Addendum No. 1

RE: Contract # C204220

Yadkin County (B-5389)

BRIDGE #105 OVER YADKIN RIVER ON US-421 NORTH BOUND LANES.

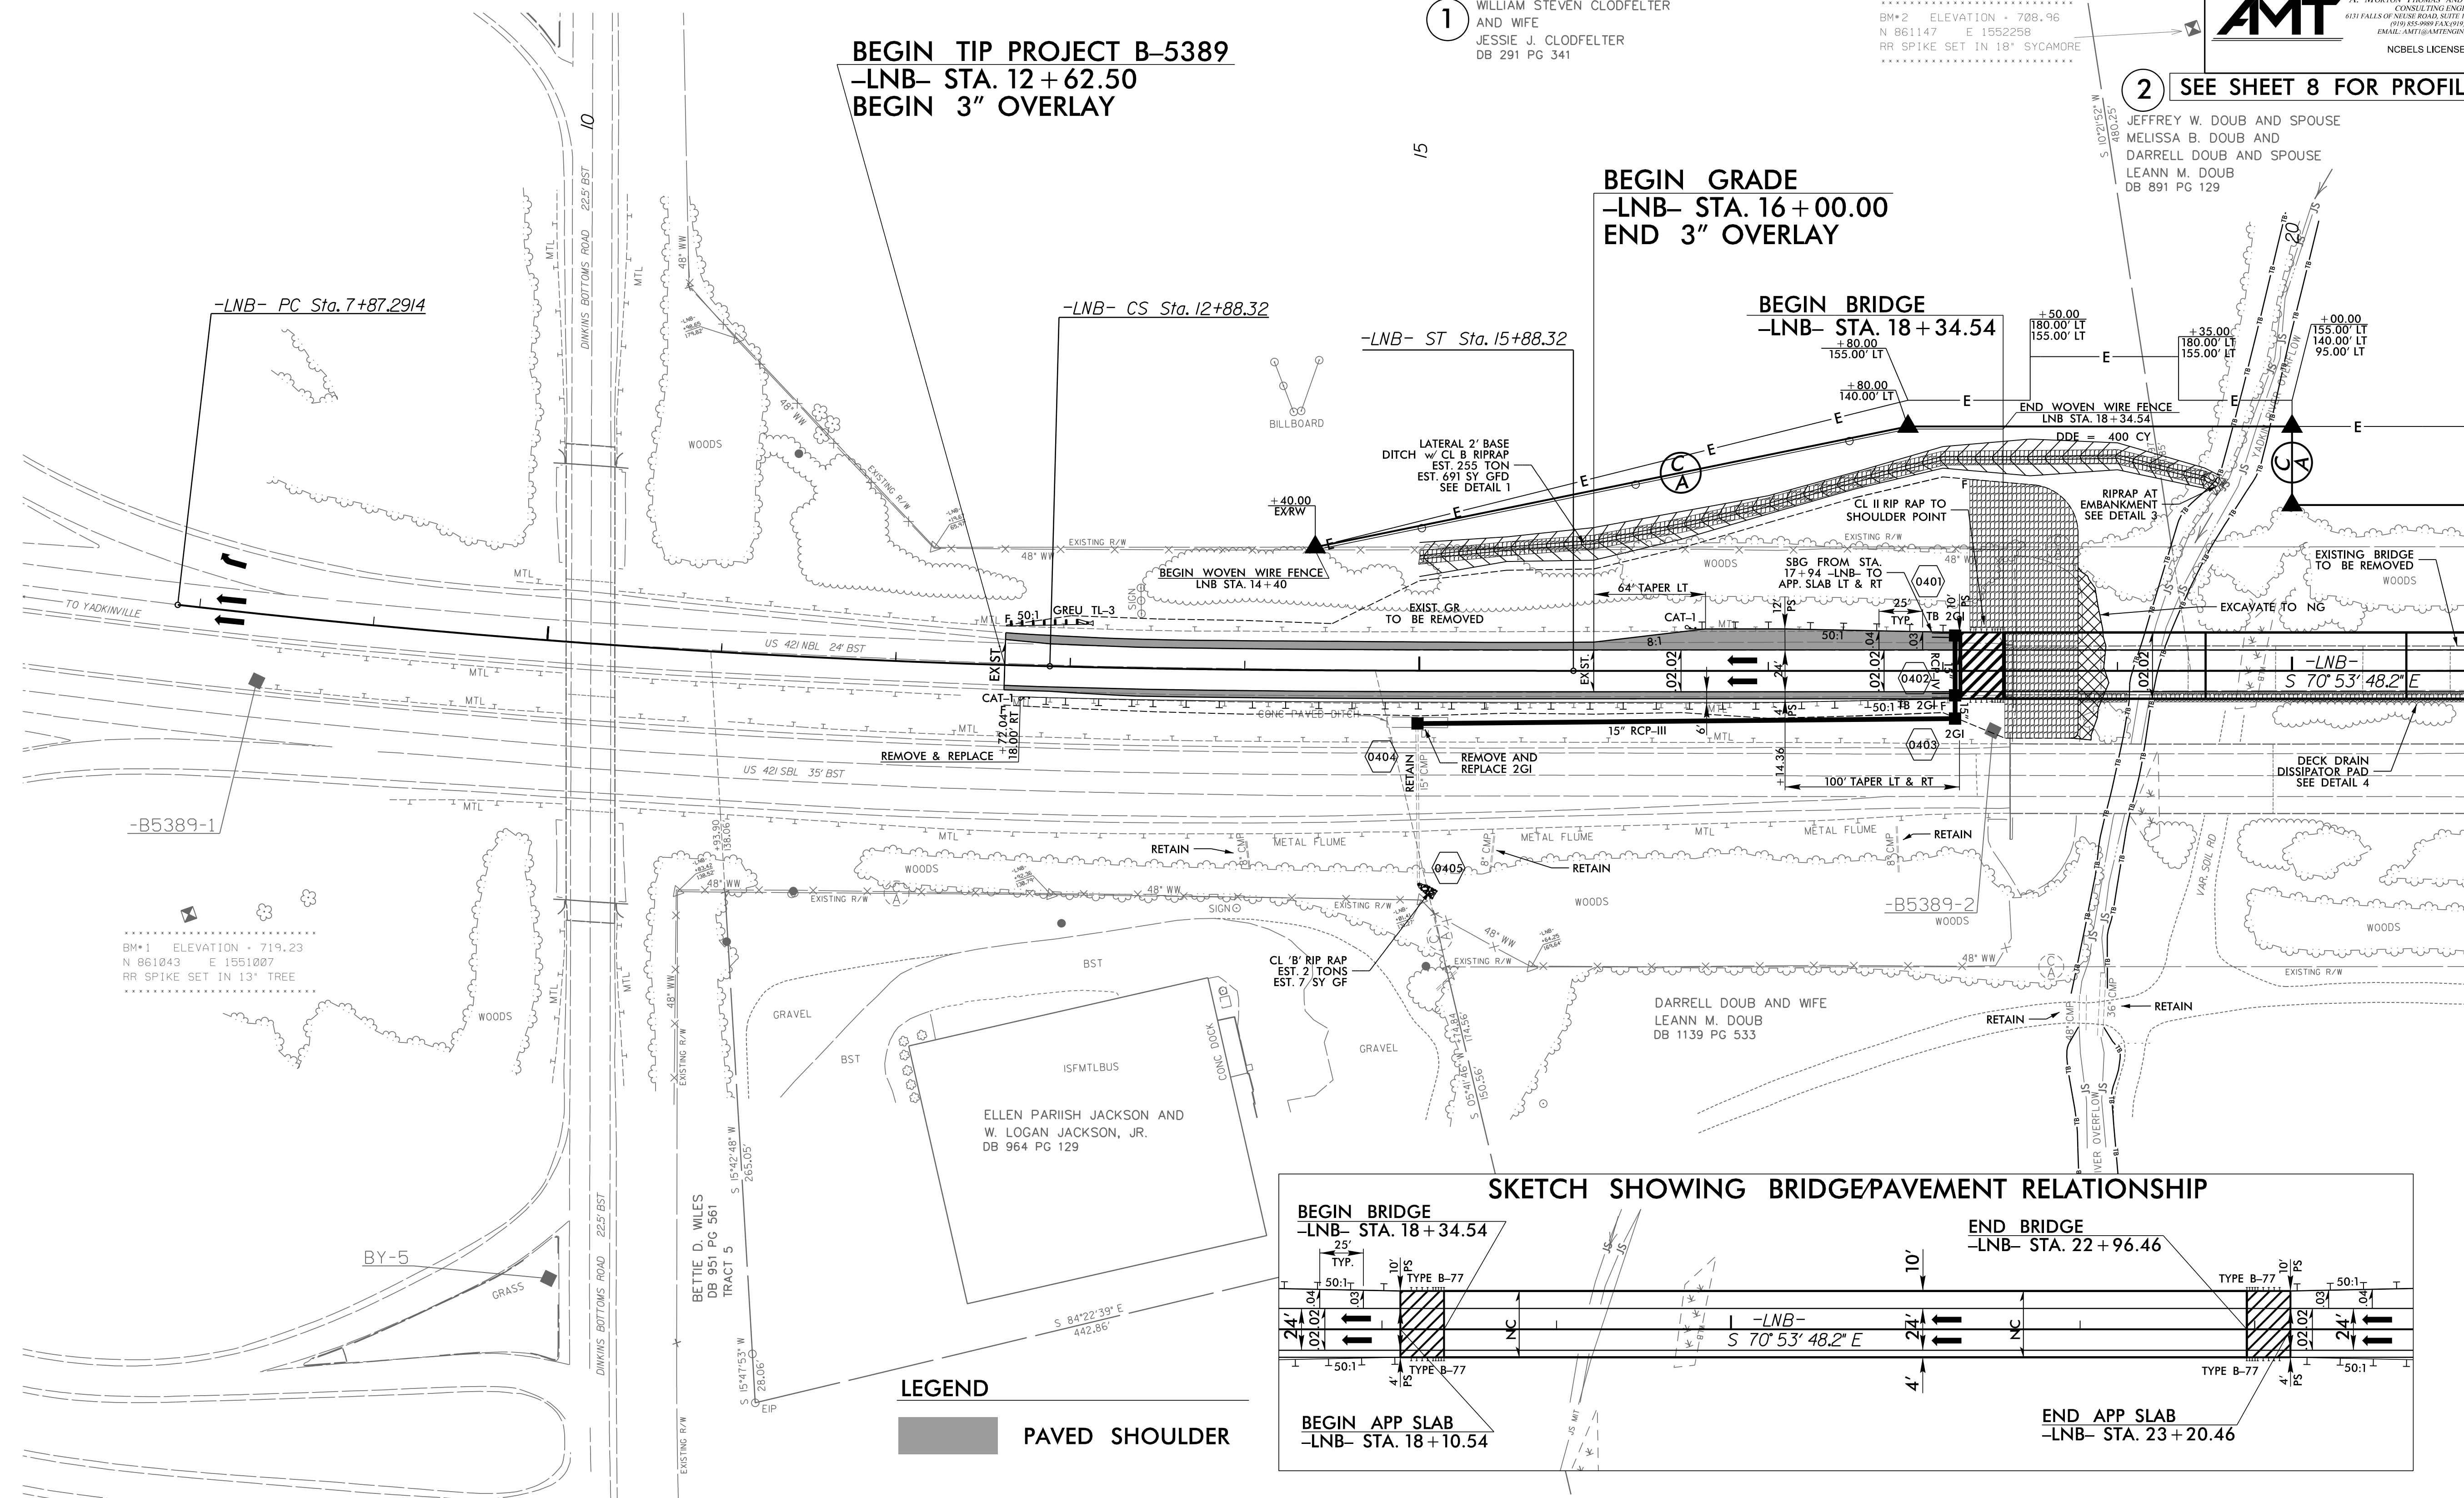
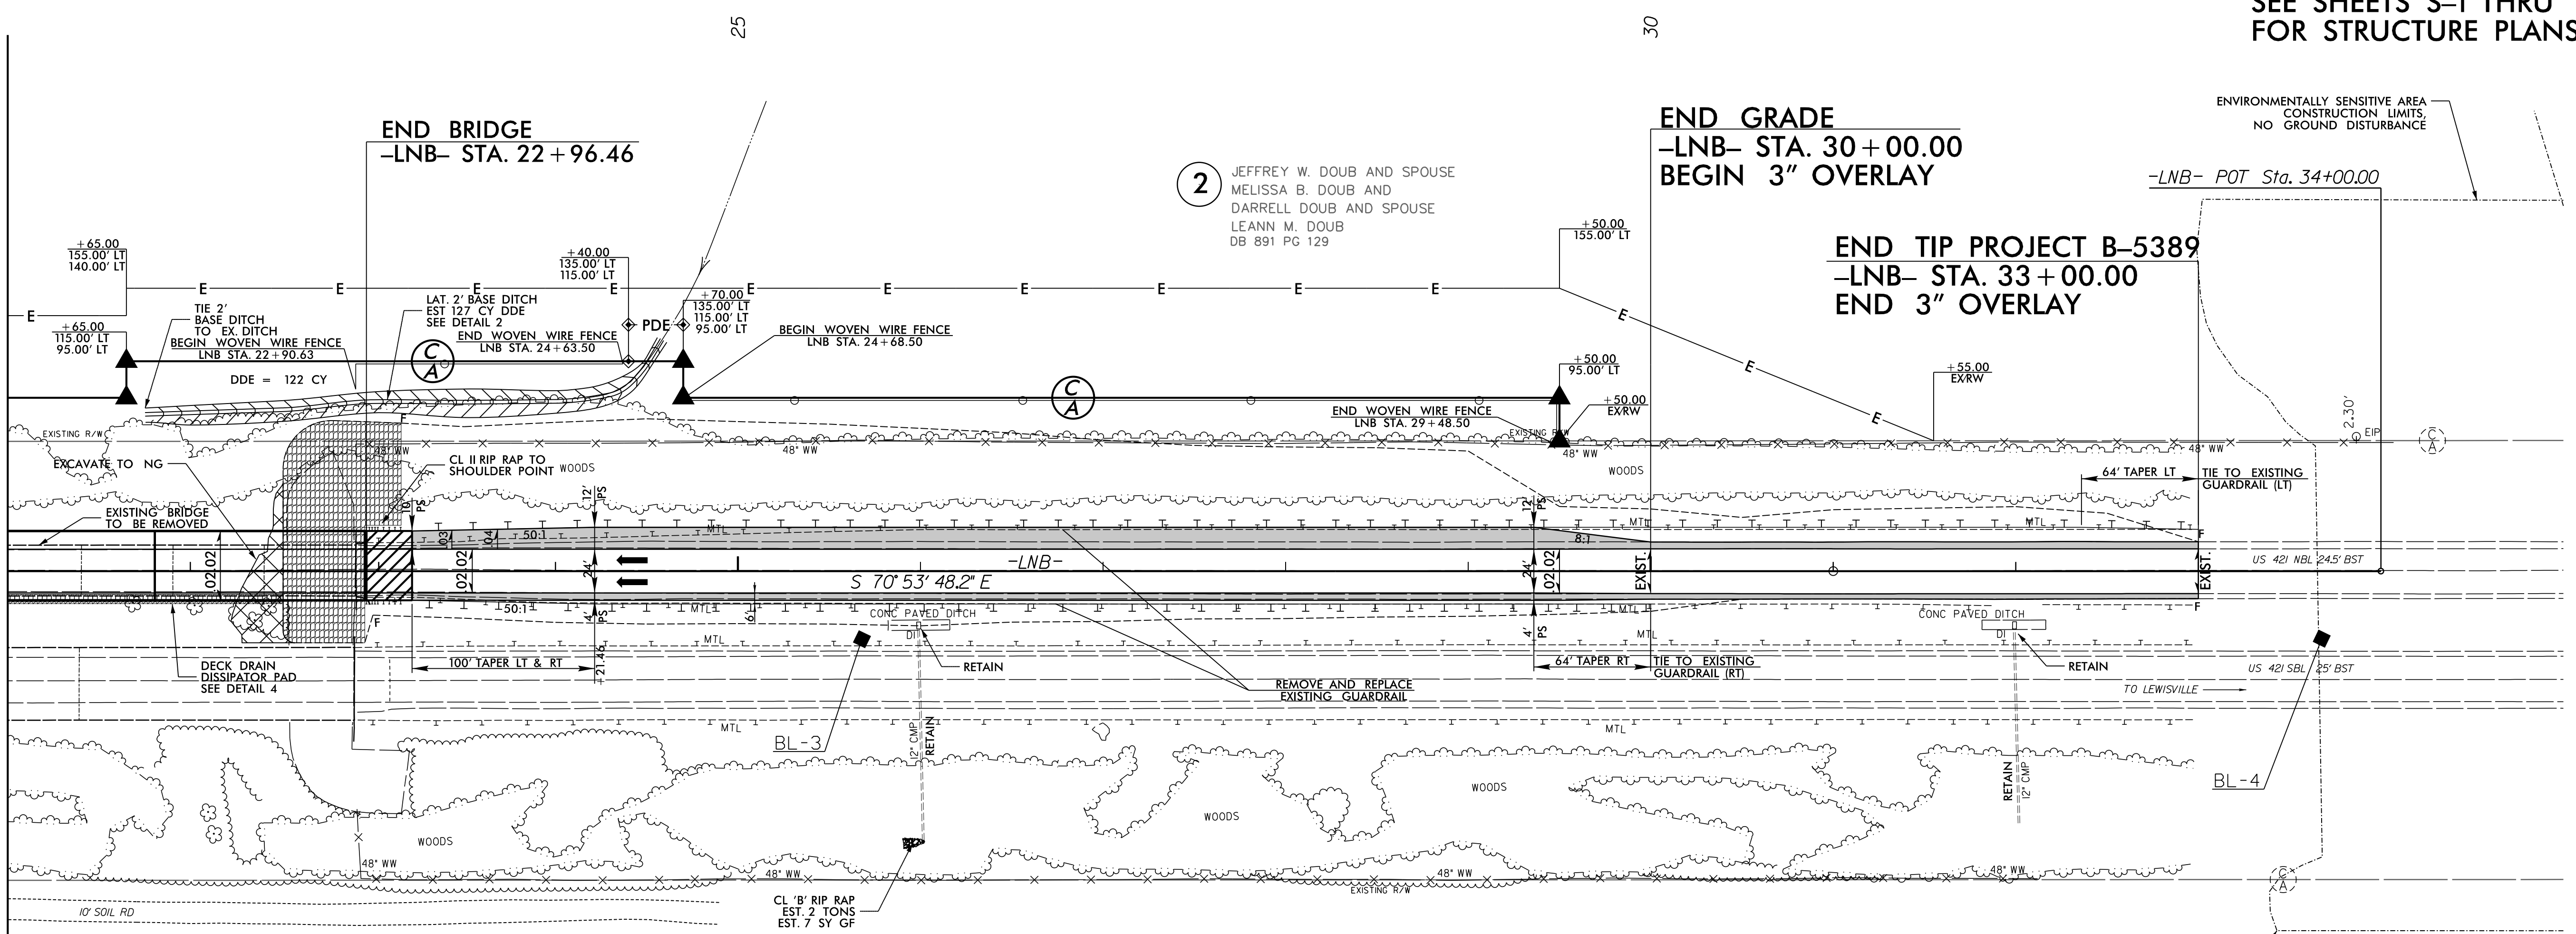
Sheet No.	Revision
5	Environmentally Sensitive Area delineated and notes added.
